OXFORDSHIRE COUNTY COUNCIL'S RESPONSE TO CONSULTATION ON THE FOLLOWING DEVELOPMENT PROPOSAL

Application no: 21/03639/F

Proposal: Replan of the western part of the residential development permitted through Reserved Matters application 19/00895/REM for the delivery of 107 dwellings

Date: 21 December 2021

Detailed Drainage Layout

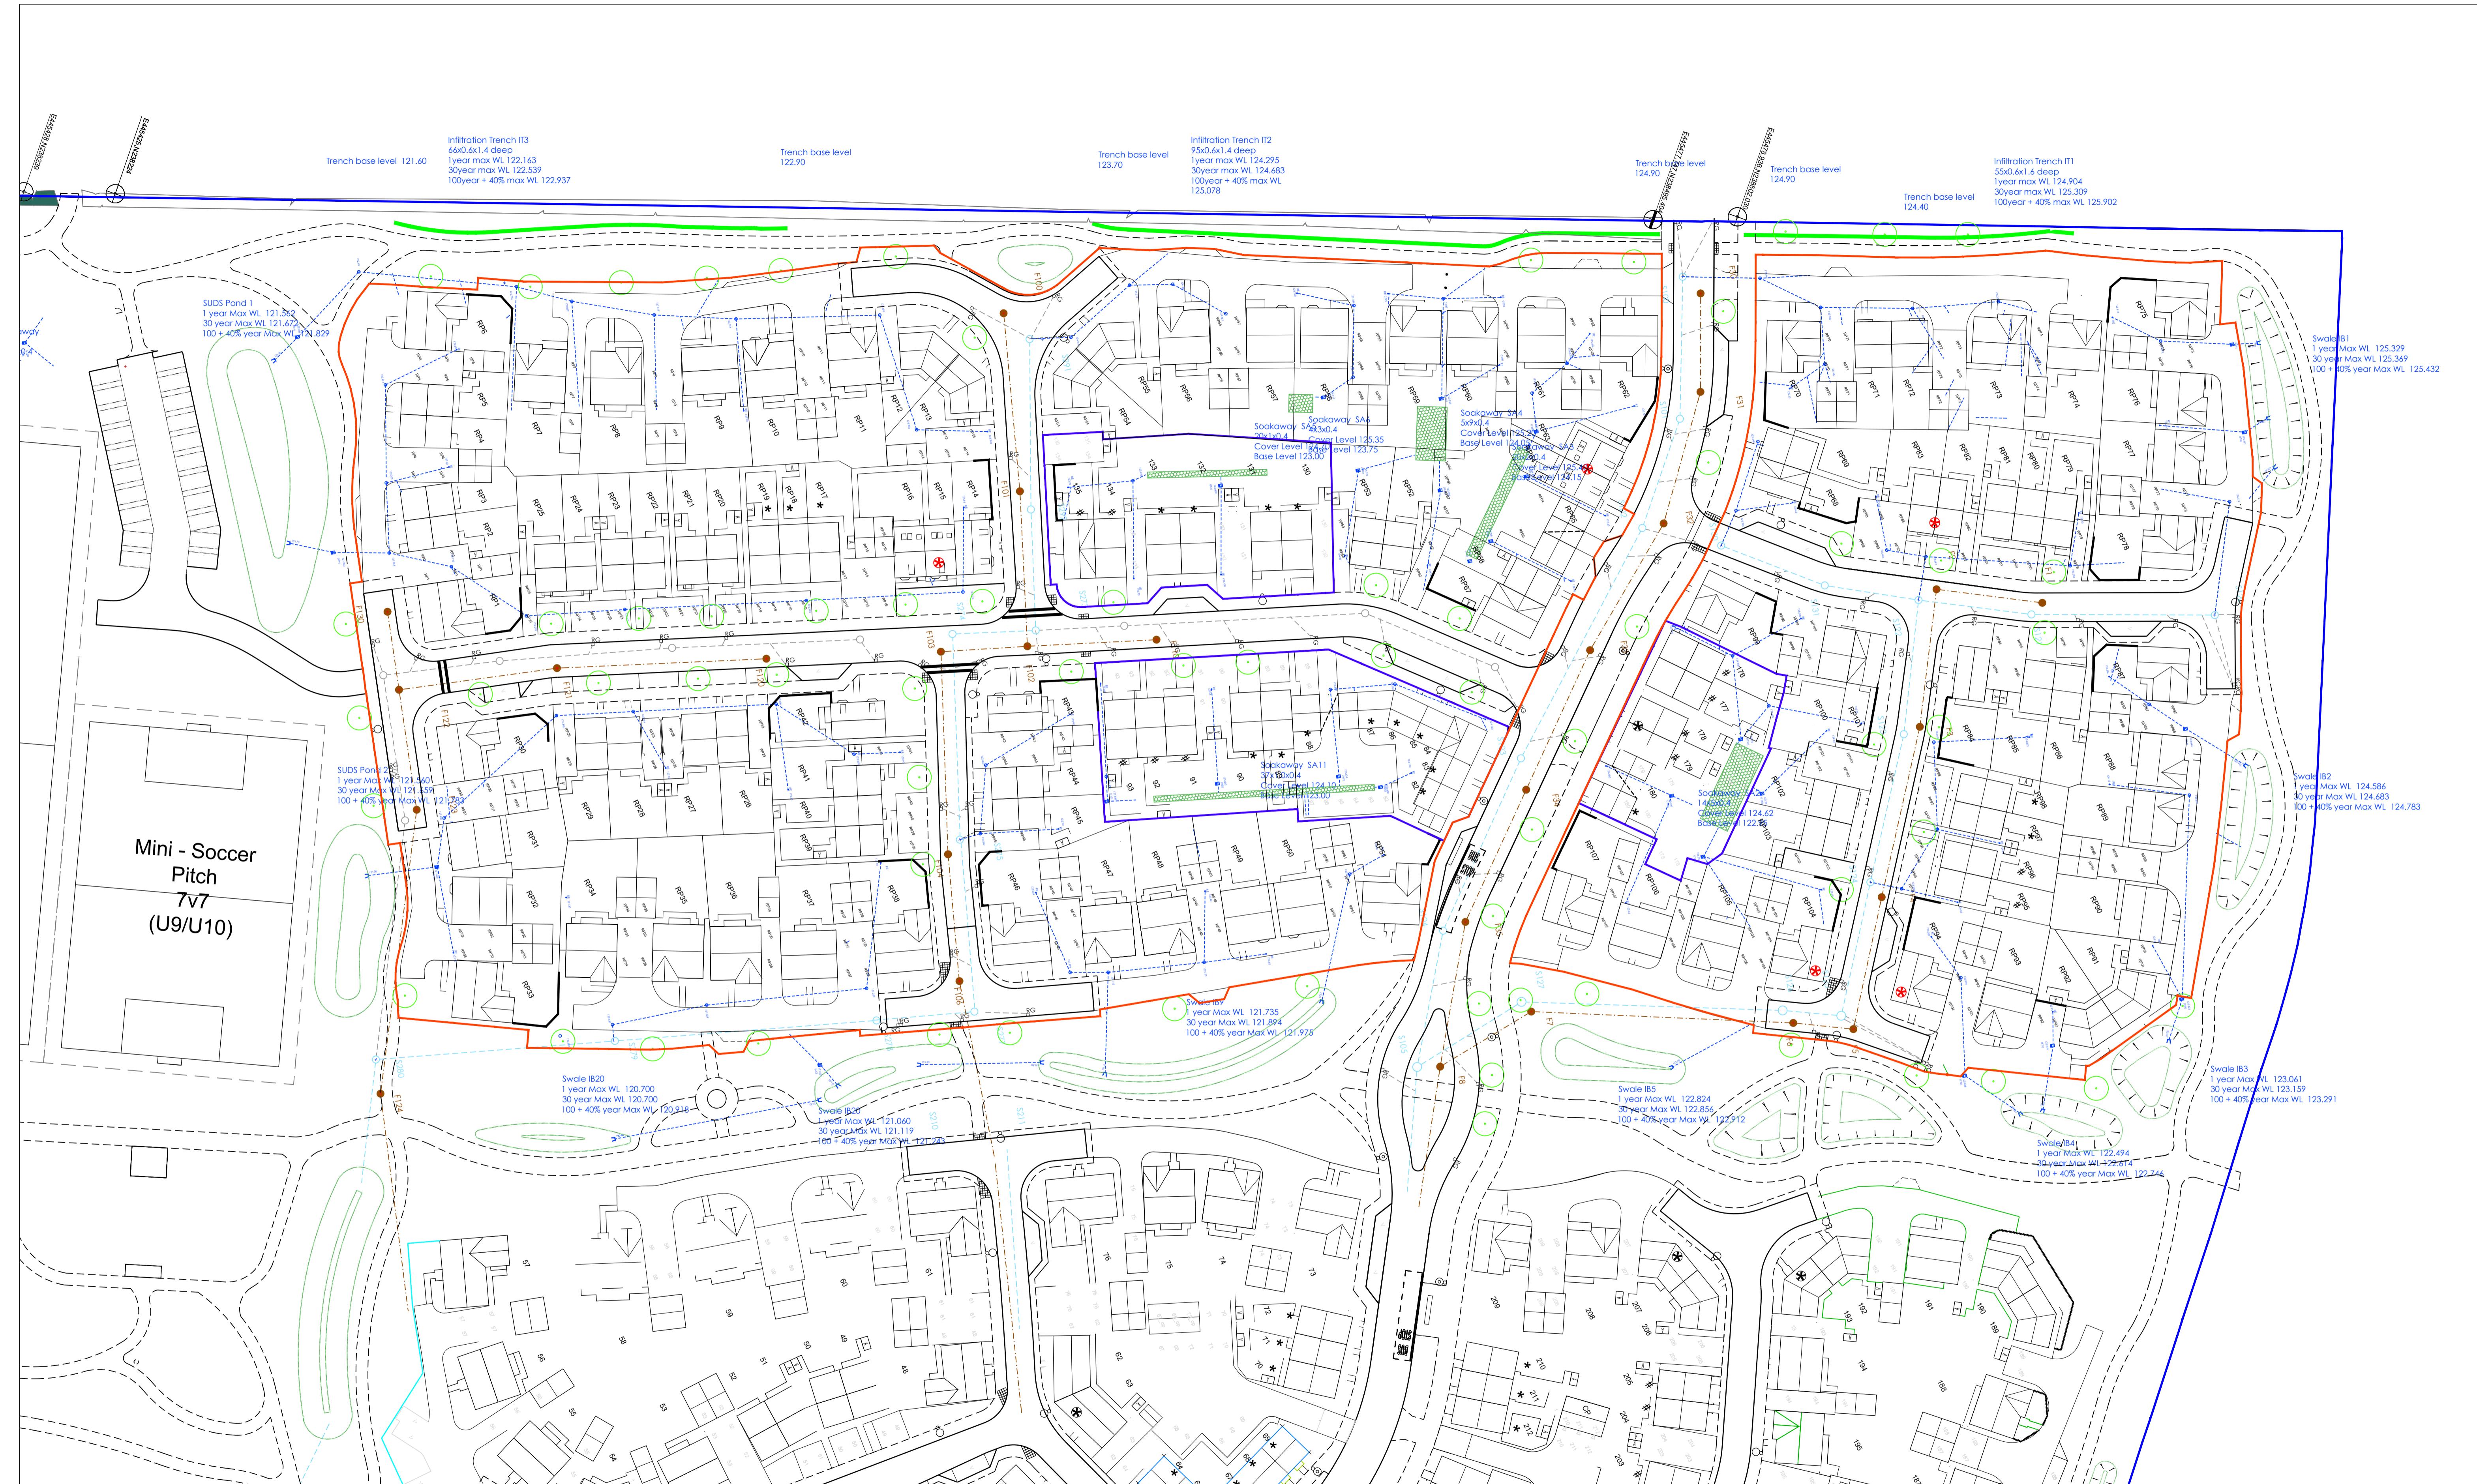
With this scale of site, as LLFA, we expect to see more SuDS being utilised in the proposal.

Where infiltration has been proposed, report of infiltration testing in accordance with BRE365 must be submitted.
